Consultation Response from KC, Lead Local Flood Authority		
2020/92546 Land off, Blackmoorfoot Road and Felks Street, Crosland Moor, Huddersfield, HD4 7AD		
Outline application (with details of points of access only) for the development of up to 770 residential dwellings (Use Class C3), including up to 70 care apartments (Use Classes C2/C3) with doctors surgery of up to 350 sq m (Use Class D1); up to 500 sq m of Use Class A1/A2/A3/A4/A5/D1 floorspace (dual use), vehicular and pedestrian access points off Blackmoorfoot Road and Felks Stile Road and associated works.		
Date Responded: 14th March 2021	Responding Officer: Paul Farndale	Responding Ref:

Further to our comments of 3rd November 2020 FURTHER INFORMATION IS REQUIRED.

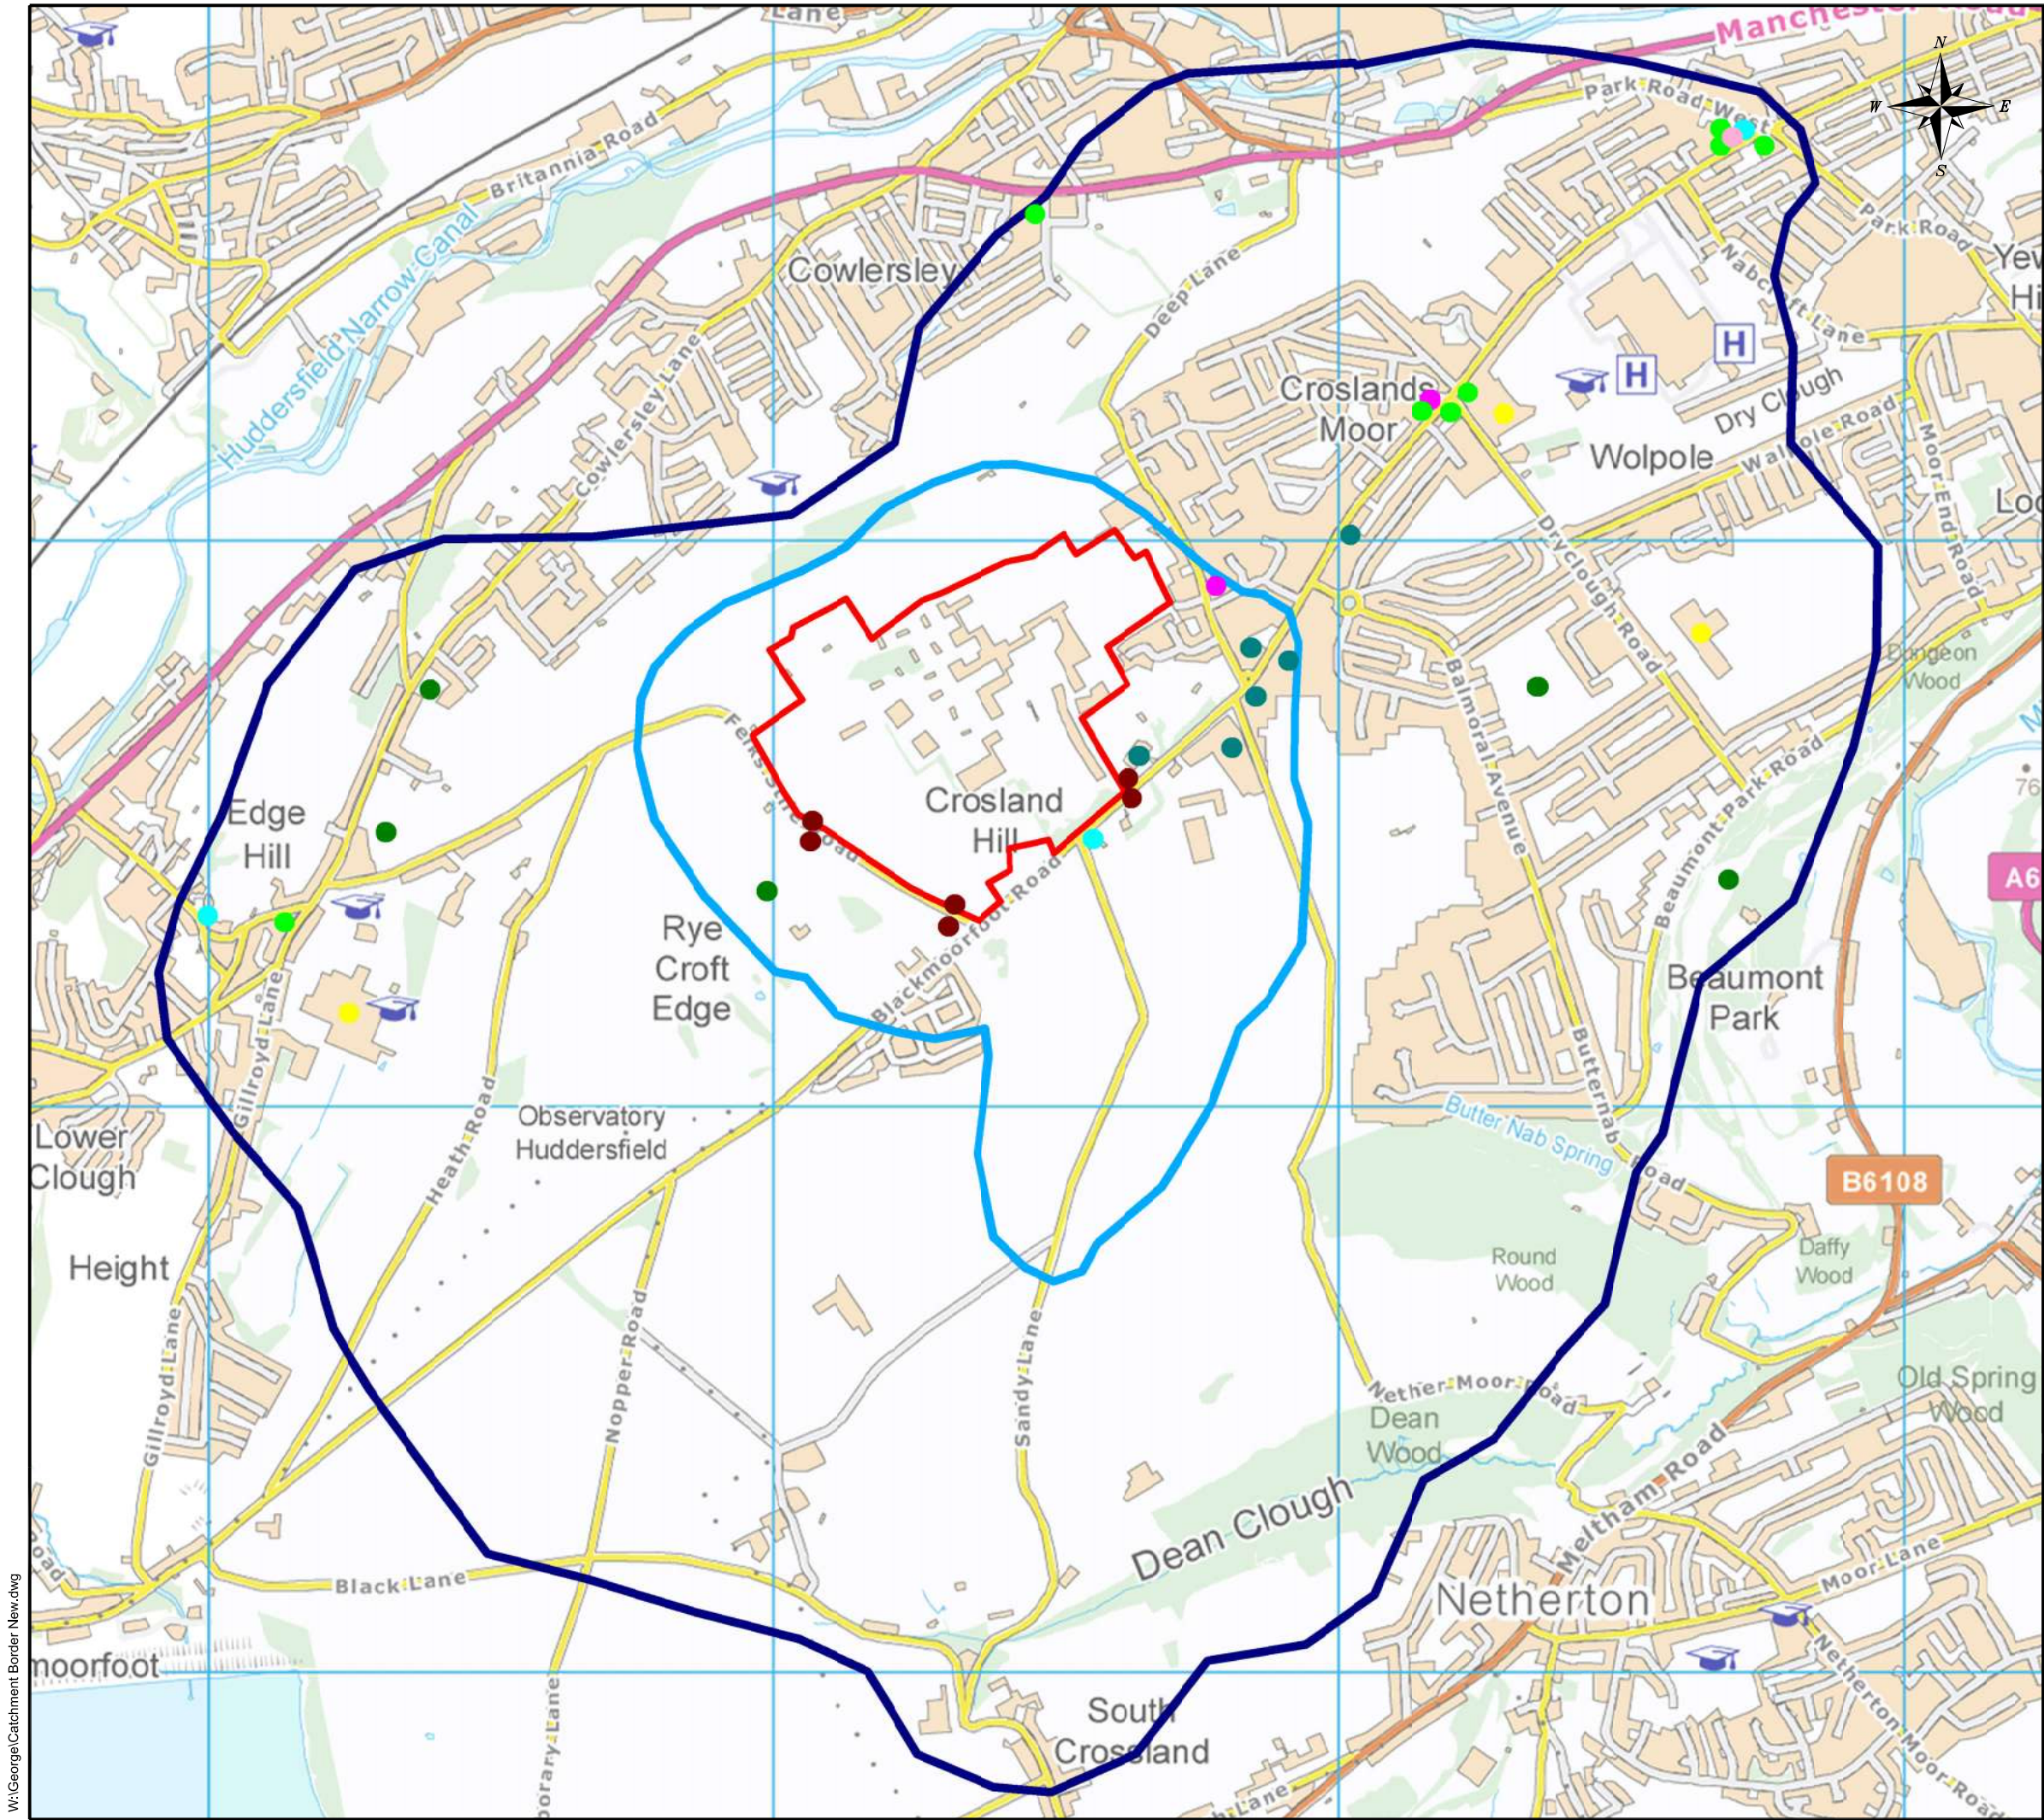
We strongly advise the planning officer to engage with Highways DC regarding Felks Stile Road, the proposed access and the existing drainage regime for the highway. Kirklees has records of a drainage ditch only to the south side of Felks Stile Road. Levels shown in the submitted Flood Risk Assessment suggest there is natural drainage from FI into the field.

We require information on the potential road upgrade for Felks Stile Road (section 38/278) and any modernisation of the drainage of the existing highway.

The inclusion of an entrance at this point is likely to allow a surface water flood route into the site that currently does not occur. This must be fully assessed in the initial flood risk assessment as access is to be decided upon. In the first instance we would look for such a route from outside the site to be avoided if practicable and flood risk will not increase elsewhere.

Appendix 6: Preliminary Drainage Strategy

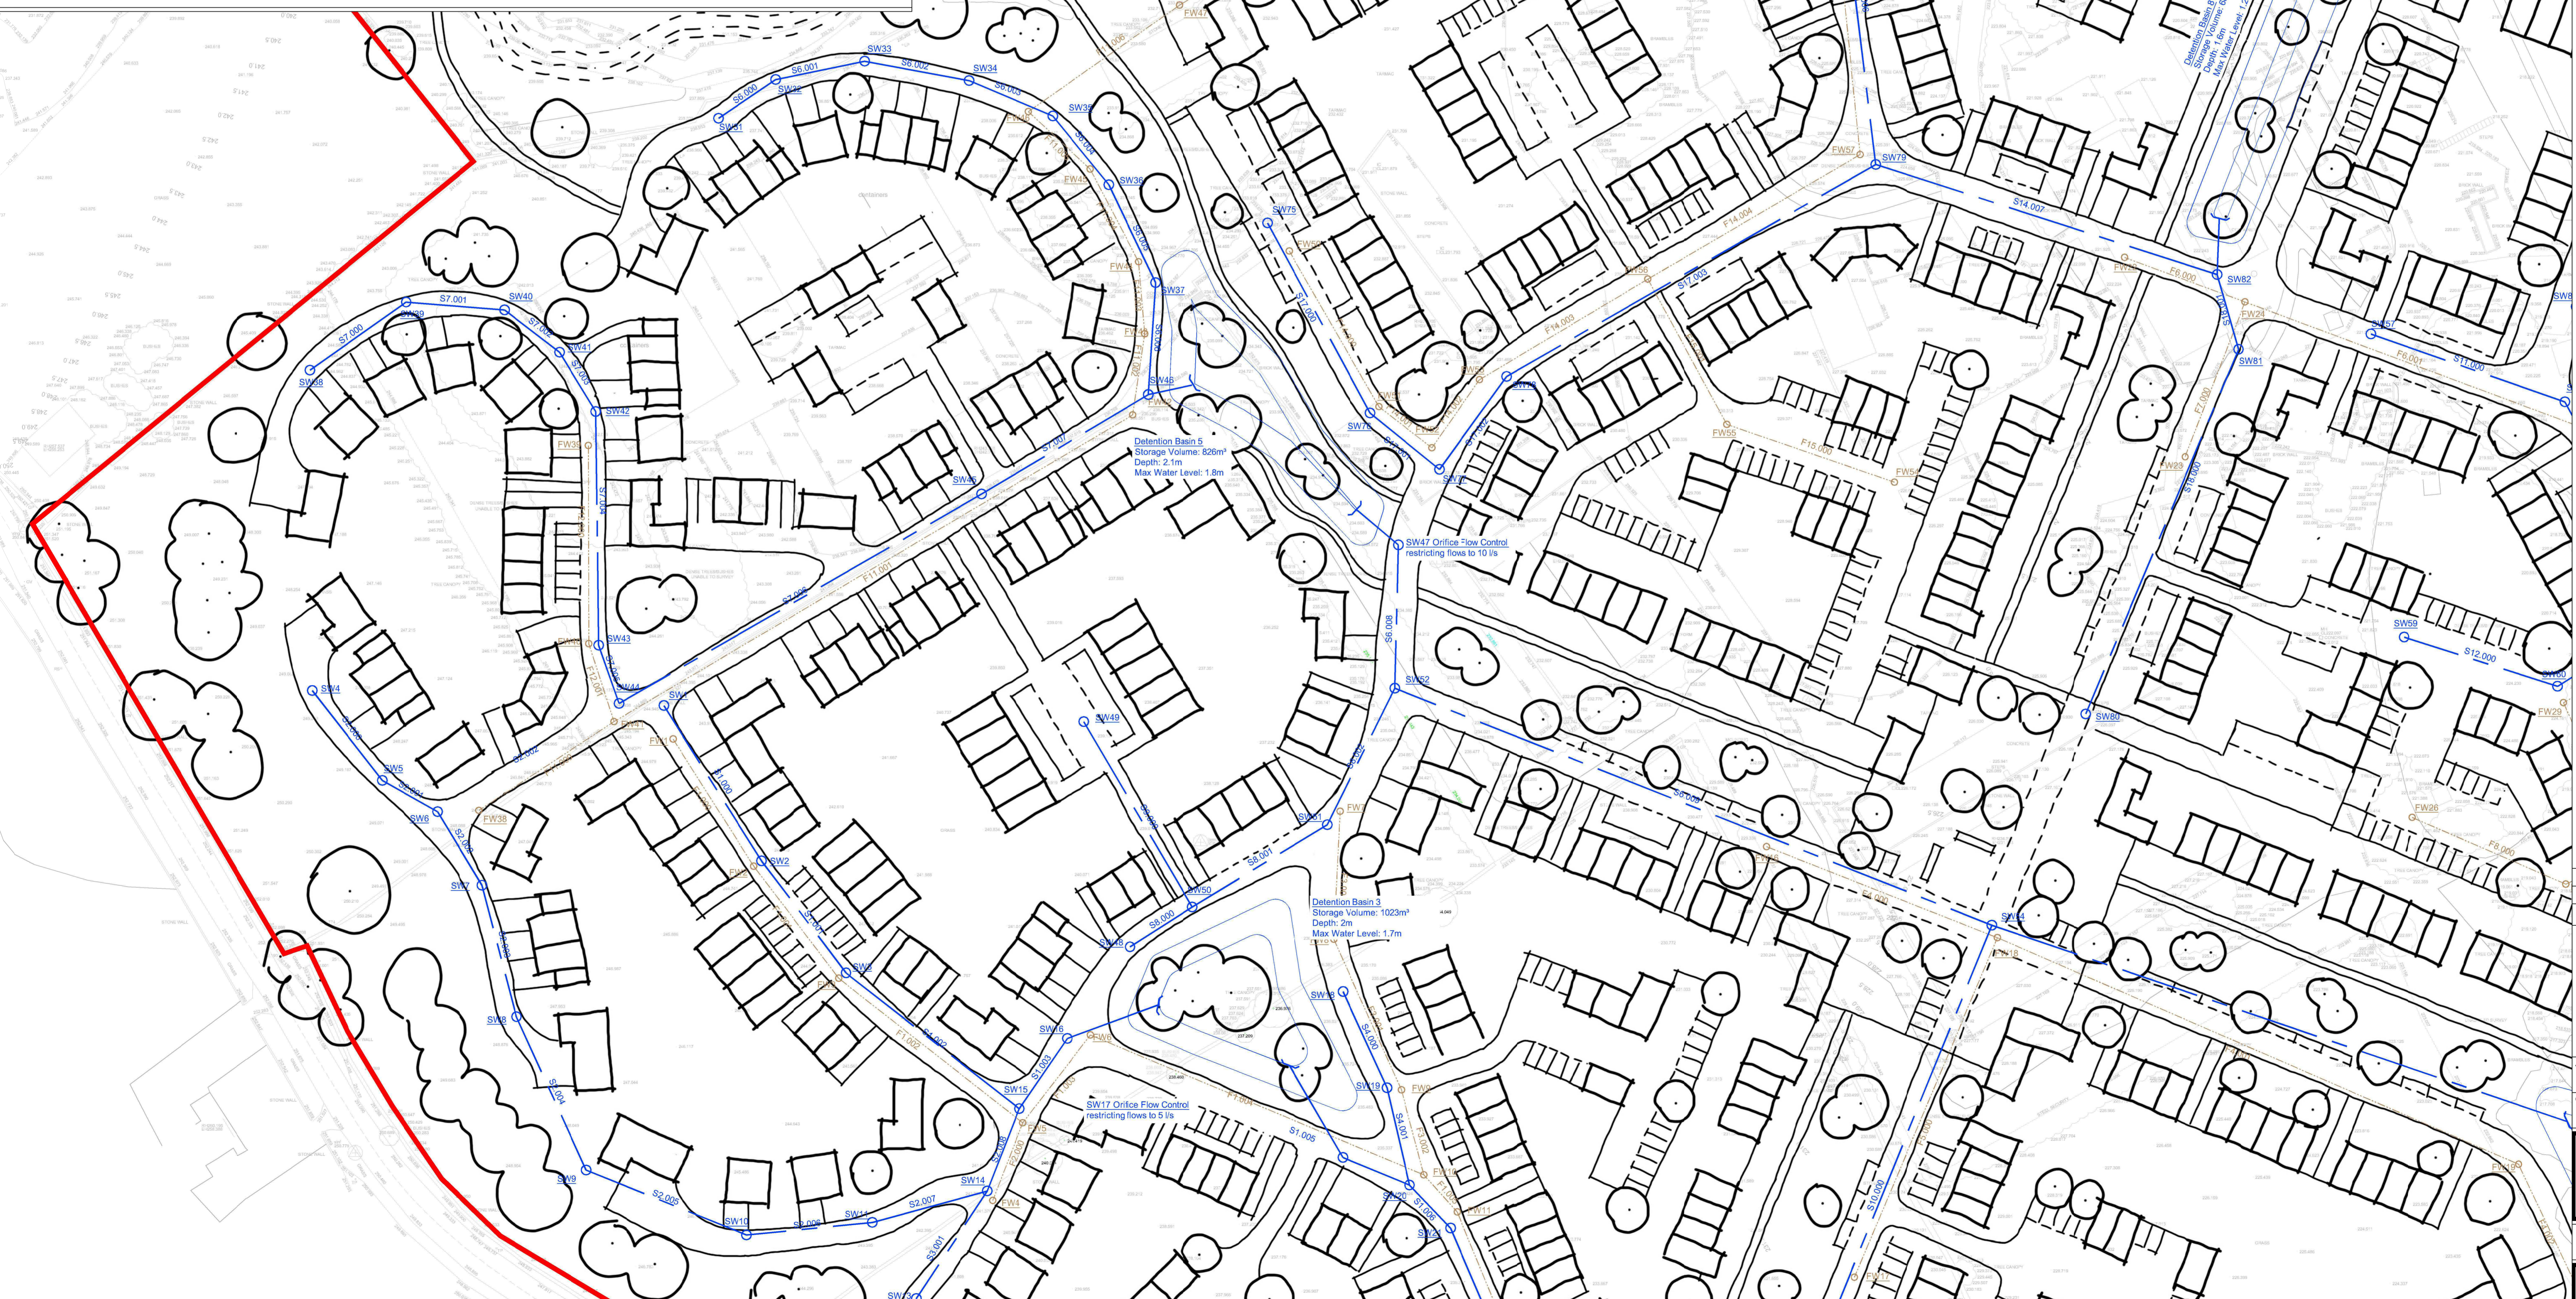
It is noted an indicative drainage/layout plan has been provided showing that with previously agreed discharge rates of 27l/s and 61l/s, surface water attenuation can be provided on site incorporating the stated number of properties/units. Detailed design conditions for drainage can therefore apply.
